Westmead Catholic Community Education Campus (SSD-10383)
Response to Submissions

ATTACHMENT 1 – KEY ISSUES

CEL & ADMIN BUILDING
WEST ELEVATION SHADOW STUDIES

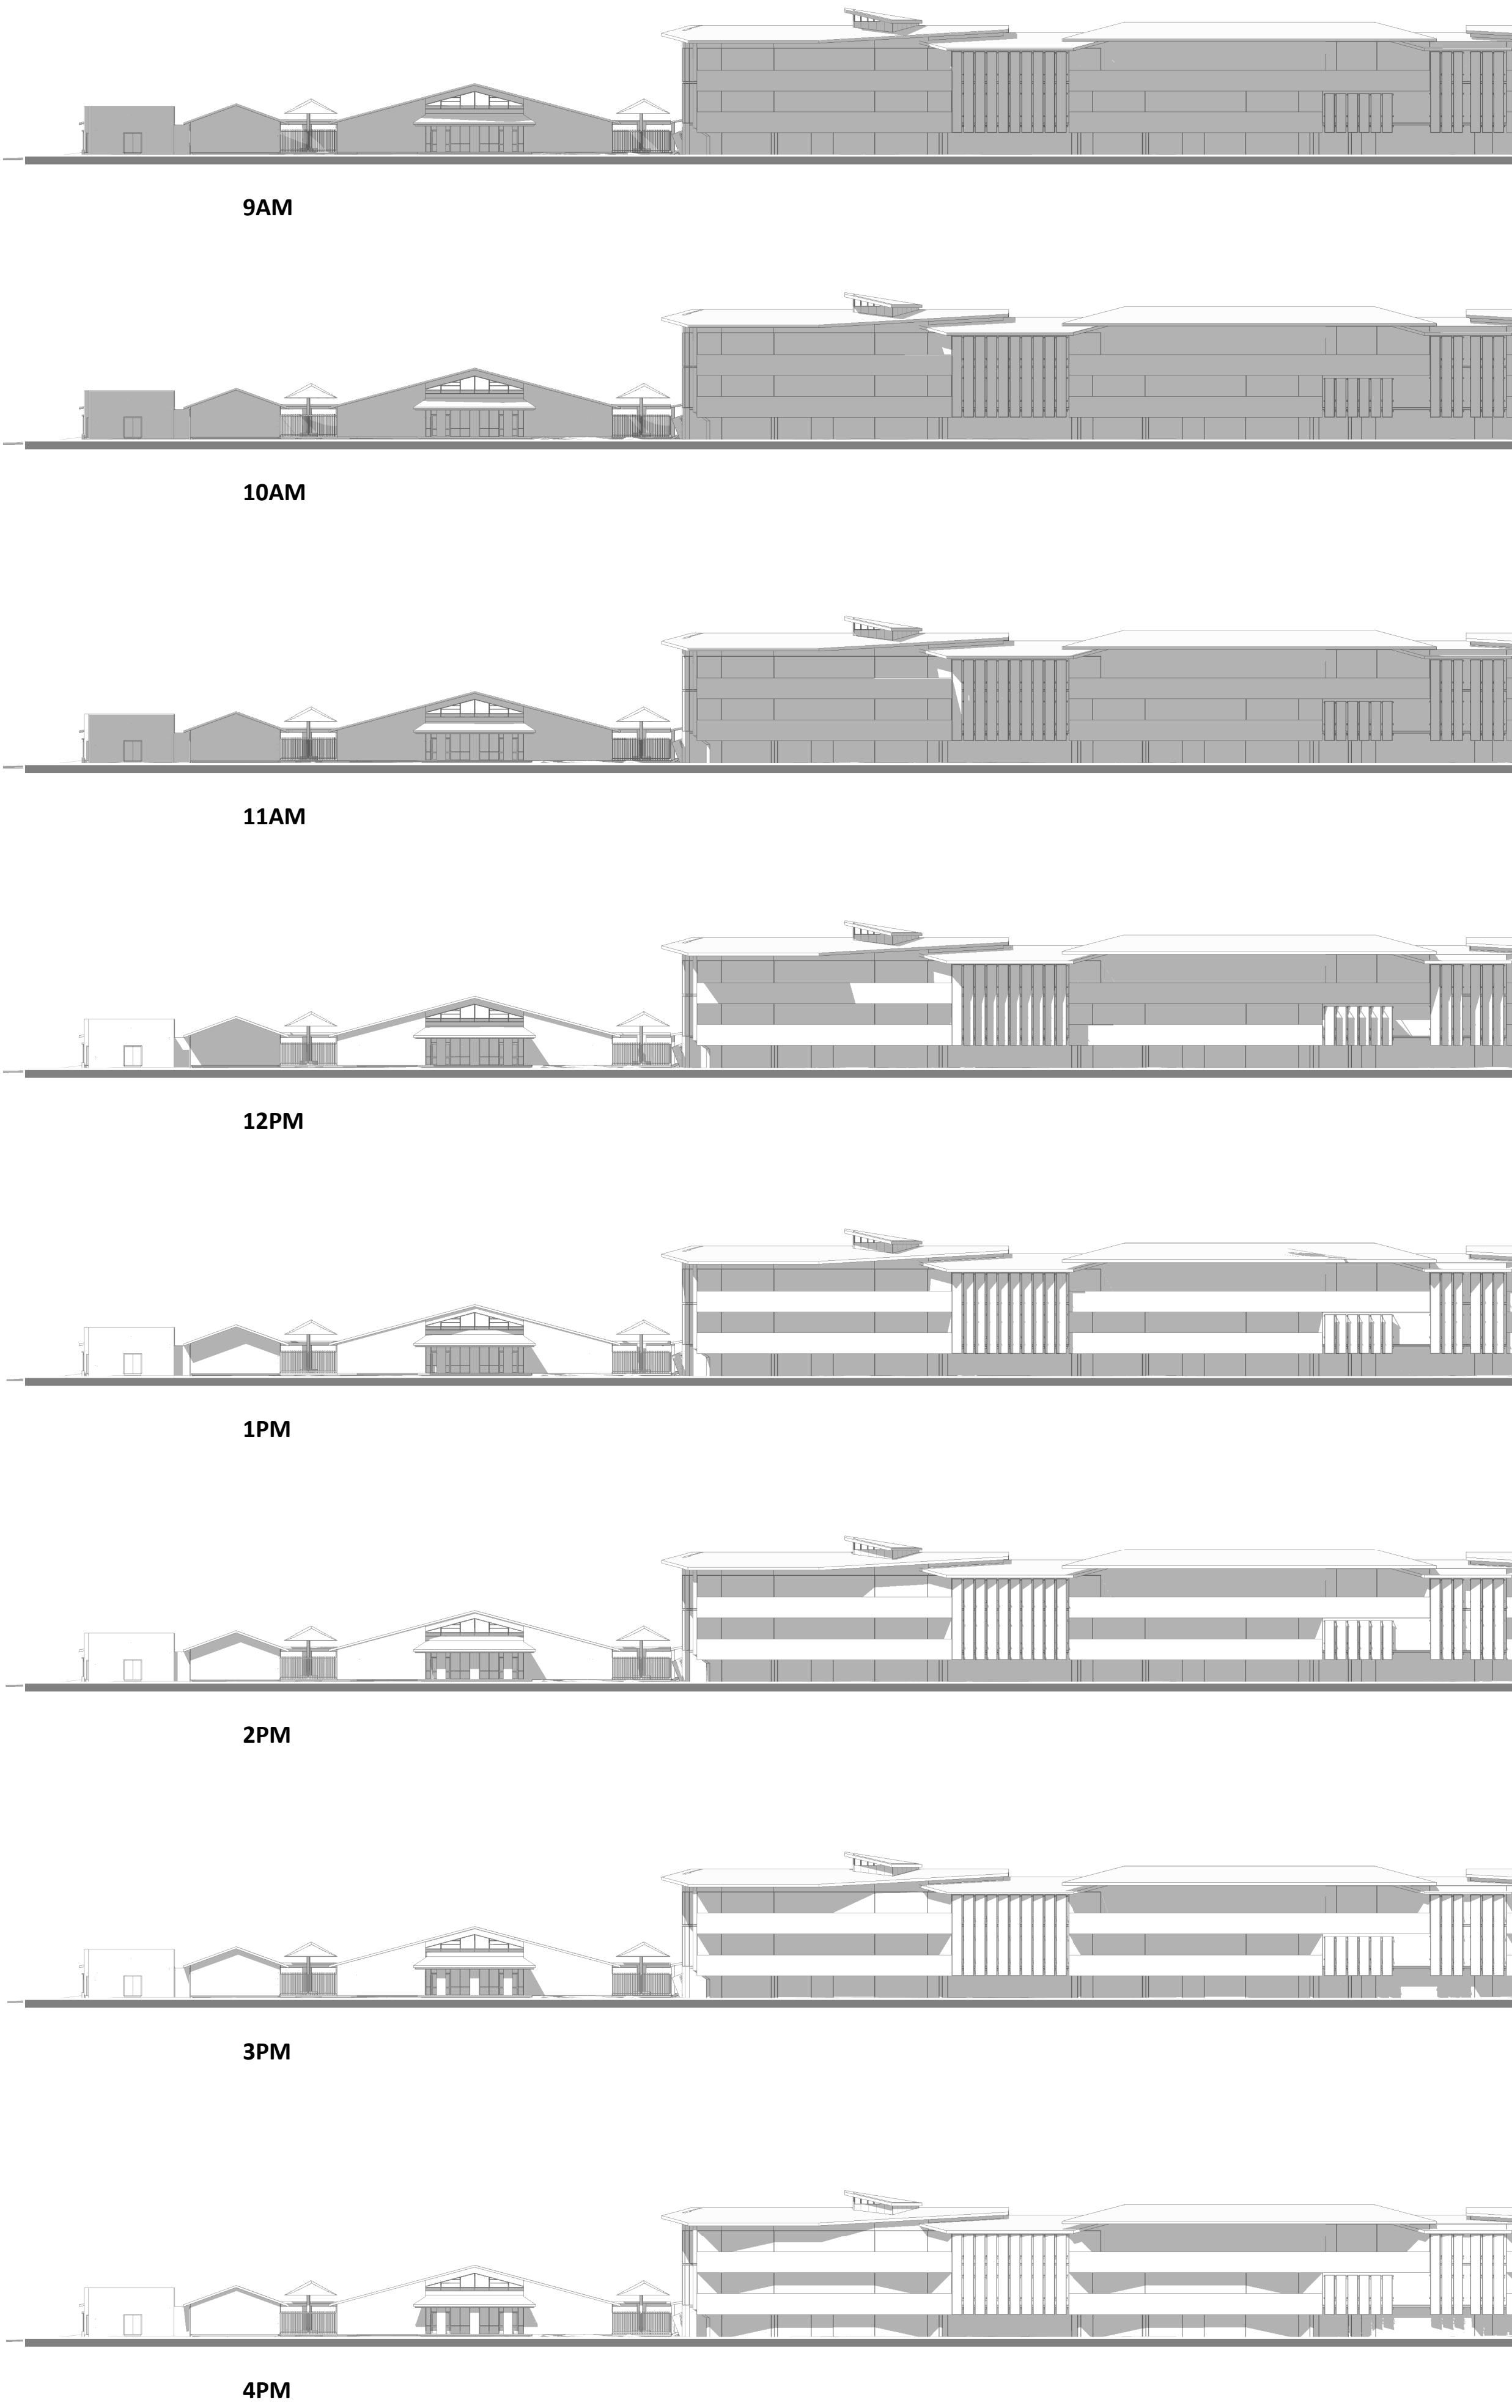
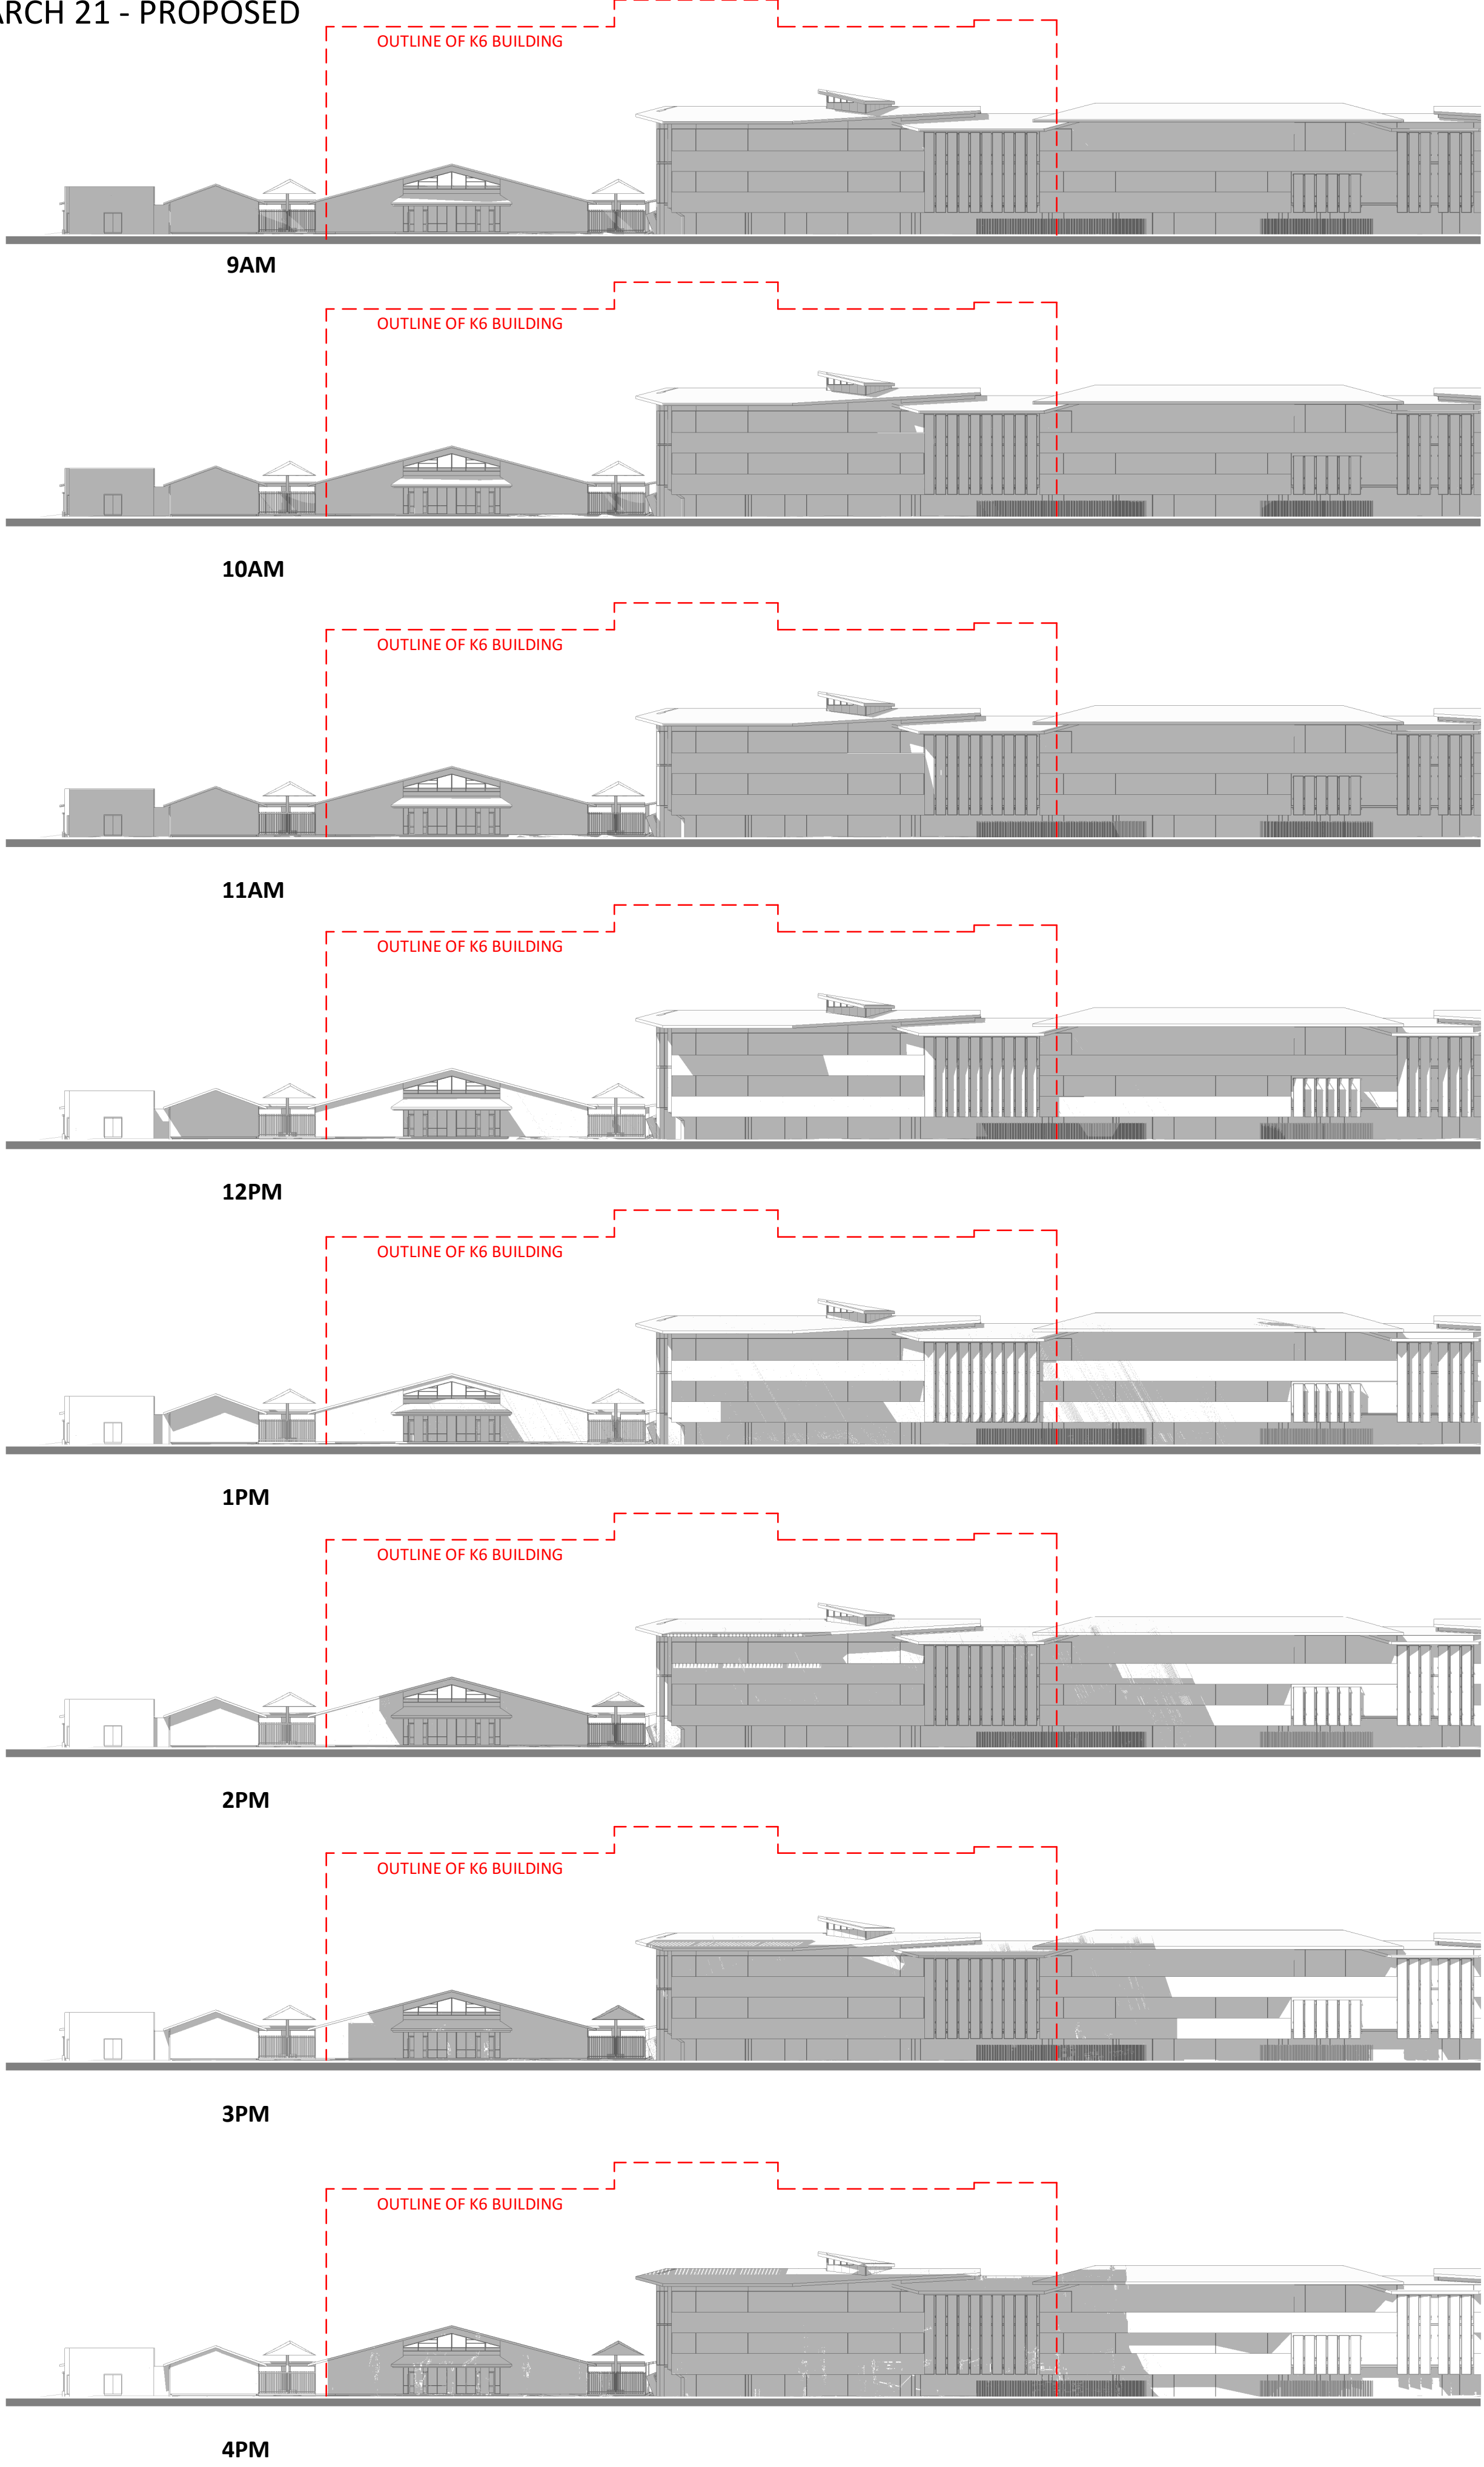
- Hourly elevational shadow diagrams are to be provided for the proposed development during the winter solstice to assess the impacts of the primary school building on the façade of the childcare centre / administrative building.
